Dean Moor Solar Farm

SCOPING OPINION:

Proposed Dean Moor Solar Farm

14 September 2023

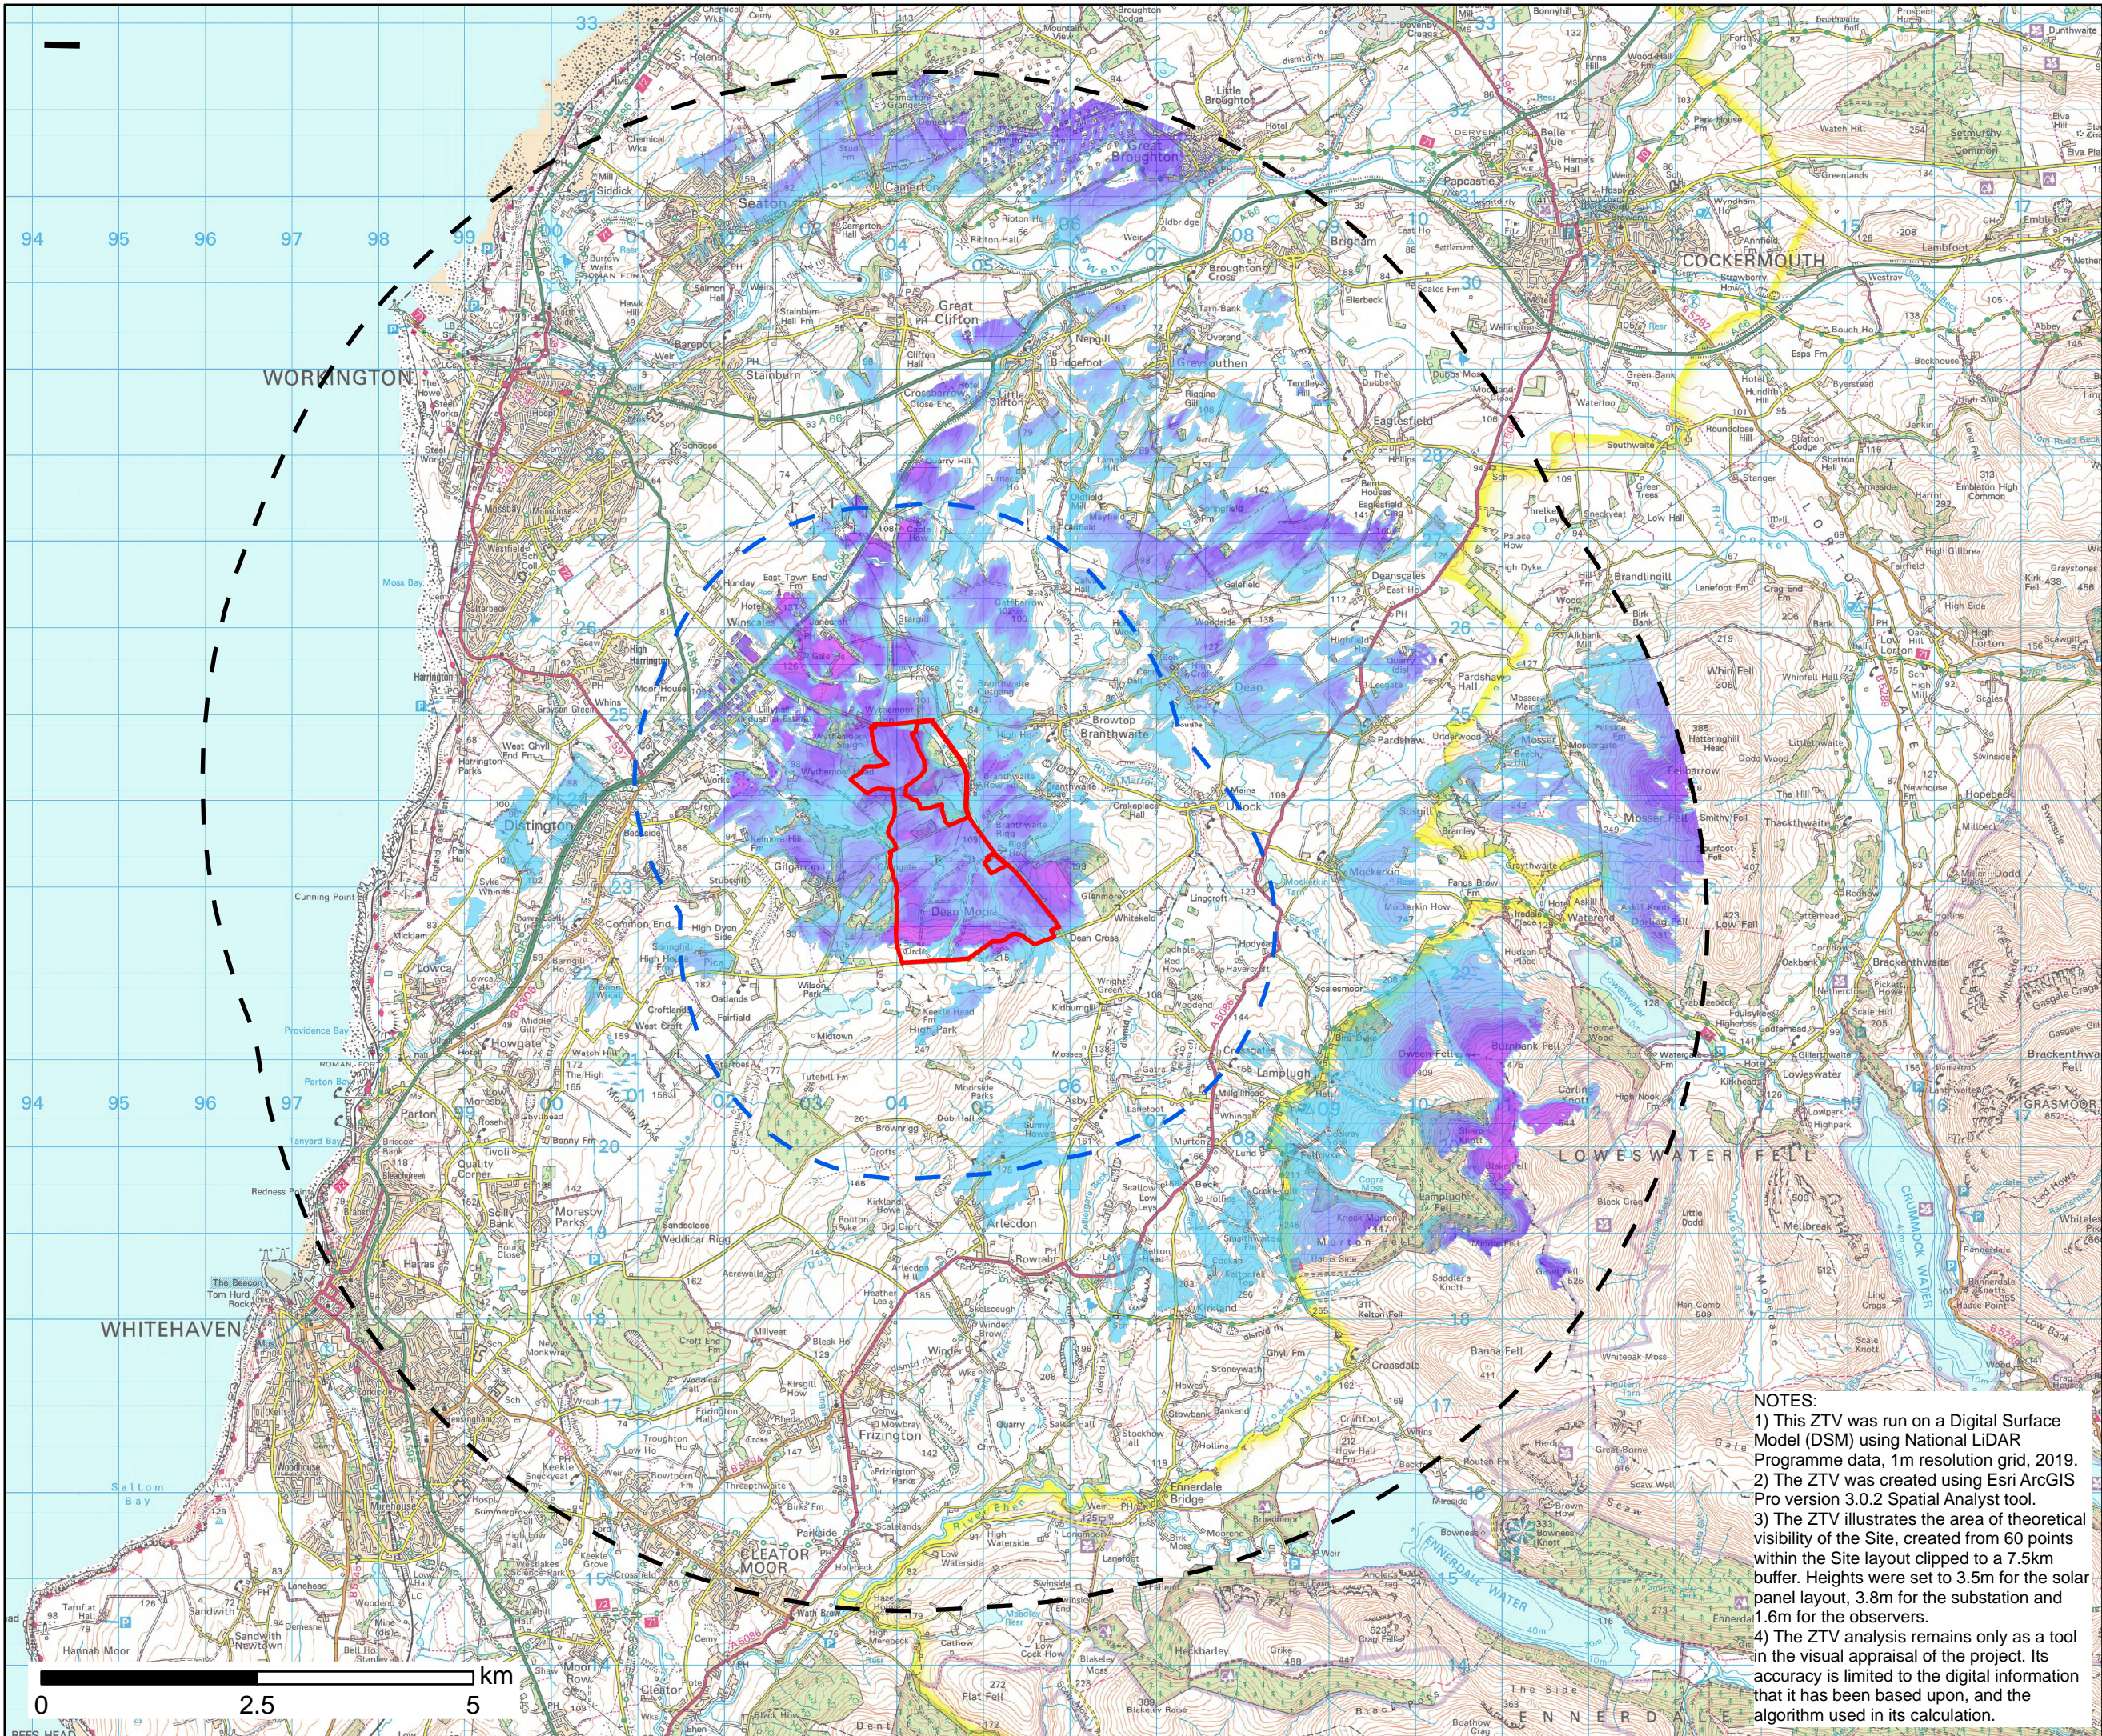
ID	Ref	Description	Inspectorate's comments
3.2.6	Paragraph, 6.3.1, 6.4.7, 6.9.5, Table 6.1, 6.2 and Figure 6.3	Zone of Theoretical Visibility (ZTV)	The preliminary ZTV and its analysis should be justified in the ES, consulted on and agreed with relevant consultation bodies.
